SSD8072: Lot 26 DP 755292; Mitchell Highway (HW7), Nevertire; Nevertire Solar Farm

Thank you for your email on the 22 February 2017 referring the *Environmental Impact Statement* (EIS) for the Nevertire Solar Farm Project to Roads and Maritime Services for comment.

Figure 2: Project Layout

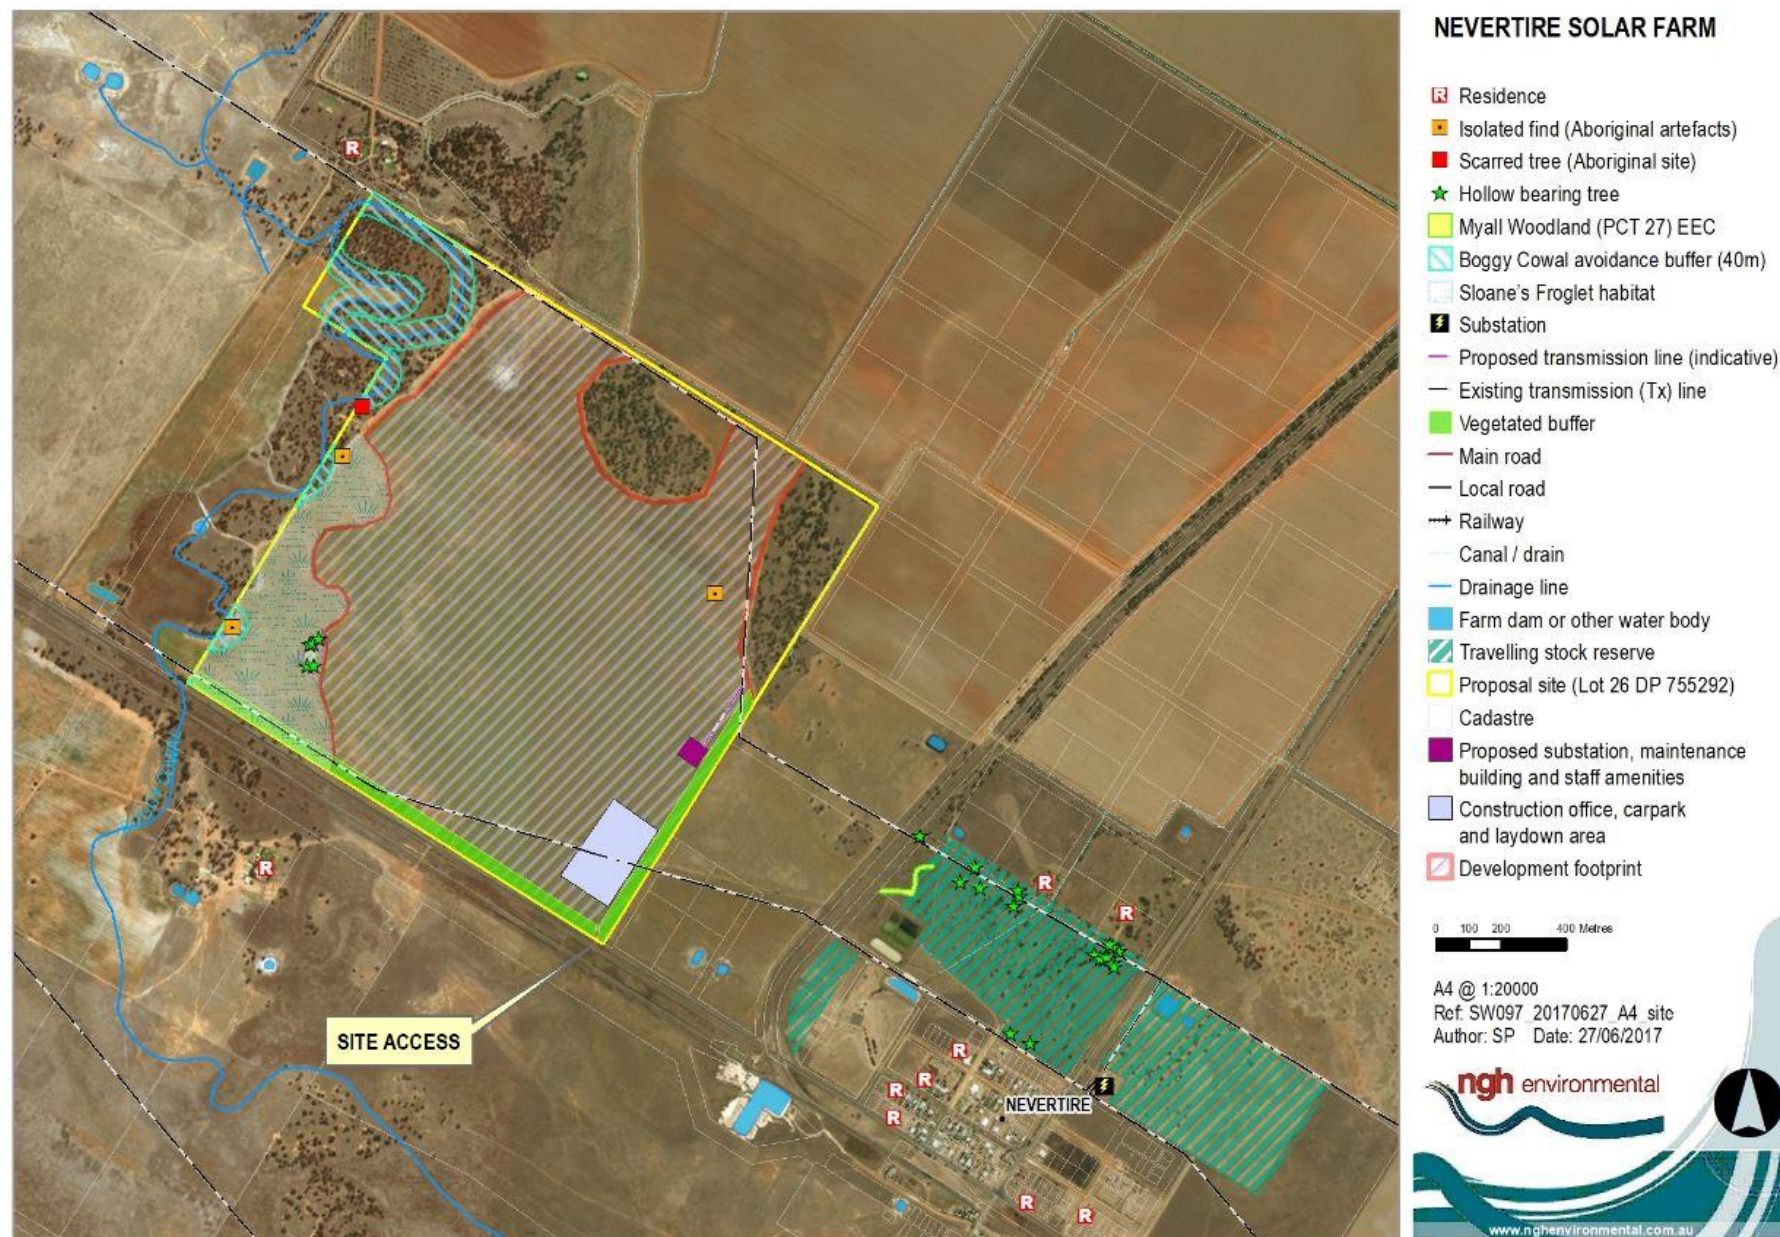
The proponent has been unable to identify the types, volumes and origin/destination of delivery, construction and personnel traffic generated during the construction period. Based on the information that has been provided, the Mitchell Highway access will require improvements to safely and efficiently accommodate traffic generated by the construction, operation and decommissioning of the project, as well as through traffic on the highway. The Mitchell Highway at this location is a signposted 110km/h speed zone and carries, on average, 1483 vehicles per day, including vehicles up to 36.5 metres in length. From the limited information provided, Roads and Maritime considers the Mitchell Highway access upgrade is likely to be more significant than the minor widening works envisaged by the applicant in the EIS.

- Prior to the commencement of construction works, the vehicular access to the subject land from the Mitchell Highway is to be upgraded. To confirm the level of access intersection works, a Traffic Management Plan (TMP) is to be prepared in consultation with Warren Shire Council and Roads and Maritime Services to outline measures to manage traffic related issues associated with delivery and construction of the solar plant, ancillary structures, any construction or excavated materials, machinery and personnel involved in the construction, operation or decommissioning of the facility. The TMP is to detail the potential impacts associated with the development, the measures to be implemented, and the procedures to monitor and ensure compliance. The TMP is to address, but not necessarily be limited to:

- (e) Scheduling of haulage vehicle movement to minimise convoy length of platoons.
 - (f) Details of access intersection improvement works in accordance with *Austroads Guide to Road Design* and Roads and Maritime supplements. Any gate or grid in the access is to be setback a distance equal to the longest vehicle required to access the site during construction, operation and decommissioning of the facility.
